Application no: H16-0839-11

Description: Proposed signage

Location: Rear of Bentleys Restaurant
Off Swan Street
Spalding
Lincs

Amendment: Design of timber edging (dwg. no. 2317-04B)

Drawing No.
04

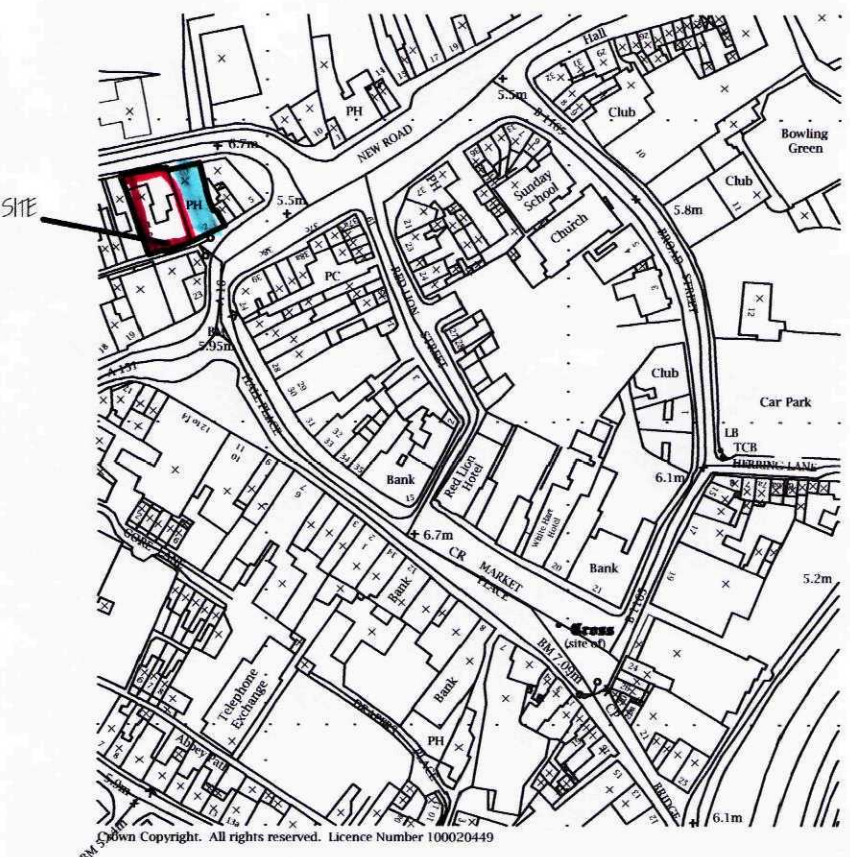
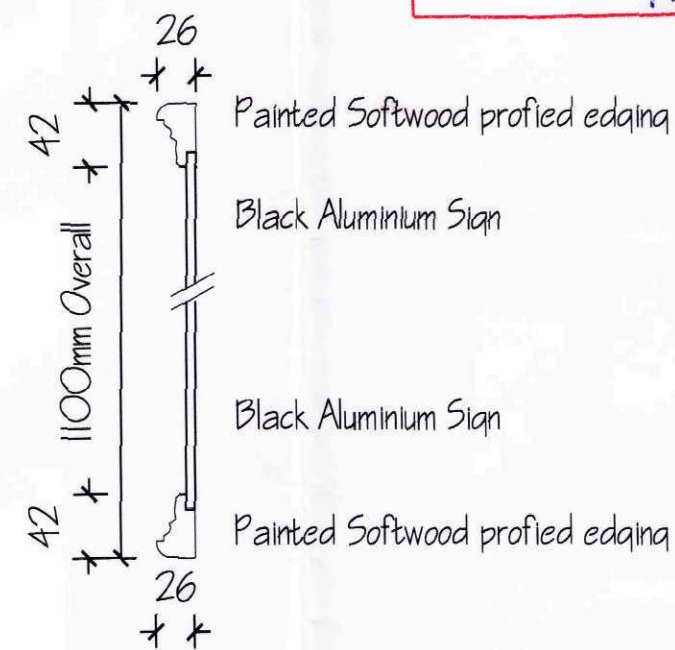
Further to the above referenced application, the submitted details are very basic. Please provide a sectional drawing showing the design of the timber edging mentioned on Dwg. No. 2317-04.

Following your email below and our recent telephone conversation on Wednesday please find attached a copy of the amended plan, as discussed. Just to confirm our client's are happy to use alluminium instead of plastic.
